SWT16/00058
SF2017/029878
MM

**SSD 7680 - PROPOSED "SUNRAYSIA" SOLAR FARM DEVELOPMENT, LOTS 9, 10, 11 & 14
DP751179, TOOLEYBUC-BALRANALD ROAD, BALRANALD.**

Roads and Maritime Services has reviewed the Environmental Impact Statement (EIS) dated January 2017 prepared by NGH Environmental for the Sunraysia Solar Farm project. From the information provided it is understood that the proposal is for the establishment and operation of a 200 MW solar photovoltaic (PV) plant and associated infrastructure, including a transmission line on the subject site. The subject site has frontage to the Balranald-Tooleybuc Road (MR694), also referred to as Yanga Way, which is a classified road, within a 100 km/h speed zone. Yanga Way is an approved road train route.

APPENDIX B SUNRAYSIA SOLAR INFRASTRUCTURE PLAN

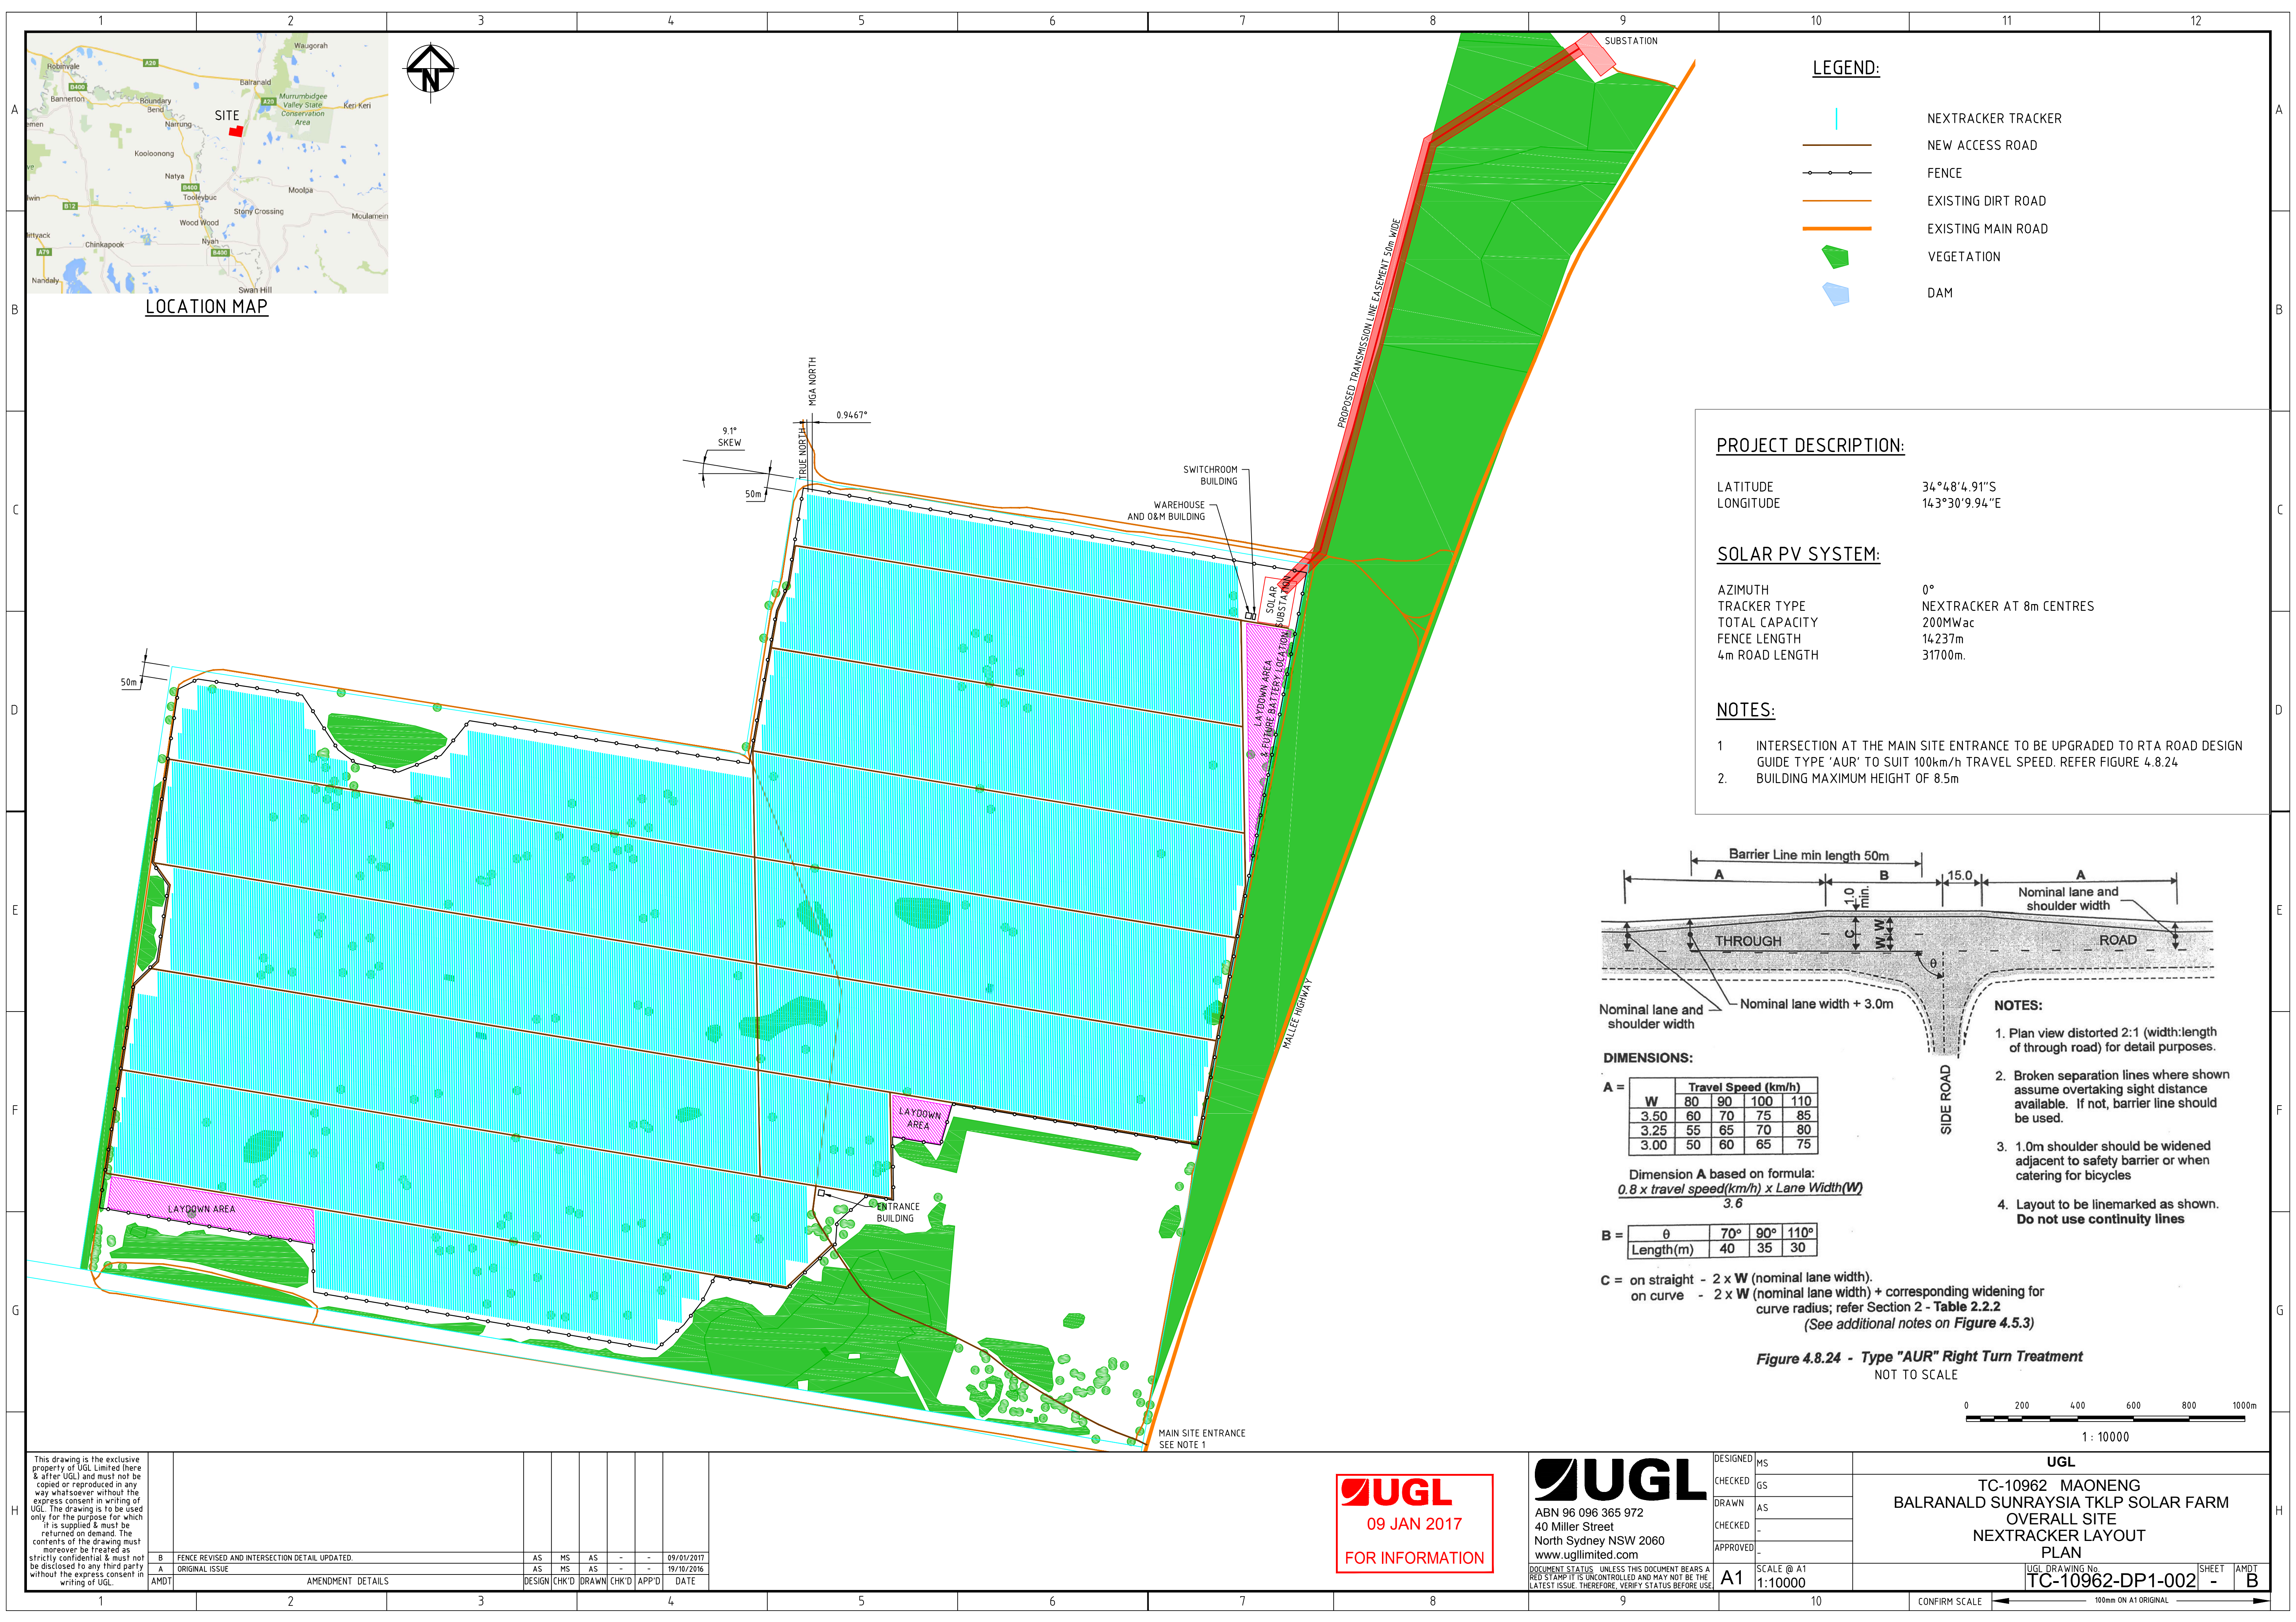
The documentation indicates that access to the site is via Yanga Way and a new intersection to be constructed on Yanga Way. It is appropriate to require that all access to the development site be via the new intersection and not various other dirt tracks that access the site. Given the potential traffic generation, including light vehicles, the submitted reports propose the construction of an Auxiliary Right Turn (AUR) intersection treatment at the intersection of the access road with Yanga Way. The Austroads Guide to Road Design proposes that Auxiliary Right Turn (AUR) treatments be replaced with Channelised Right Turn -Short (CHR(s)) treatments. Roads and Maritime Services requires that as a minimum the intersection be constructed as a Channelised Right Turn - Short (CHR(s)) and Basic Left Turn (BAL) intersection treatment and that the access road be sealed for at least 50 metres from its intersection with Yanga Way.

5. As a minimum the intersection of the access road with Yanga Way is to be constructed with a Channelised Right Turn -Short (CHR(s)) and Basic Left Turn (BAL) intersection treatment in accordance with the Austroads Guide to Road Design as amended by the supplements adopted by Roads and Maritime Services for the posted speed limit on Yanga Way. The intersection is to be constructed to the standards required for an approved road train route.

6. As a minimum the access road is to be constructed to provide for 2 way movement and be sealed for at least 50 metres from its intersection with Yanga Way. The intersection shall be designed and constructed so that vehicles turning between Yanga Way and the access road are not required to cross to the opposing travel lane in order to perform a turn manoeuvre. The intersection shall be line marked in accordance with Australian standards.
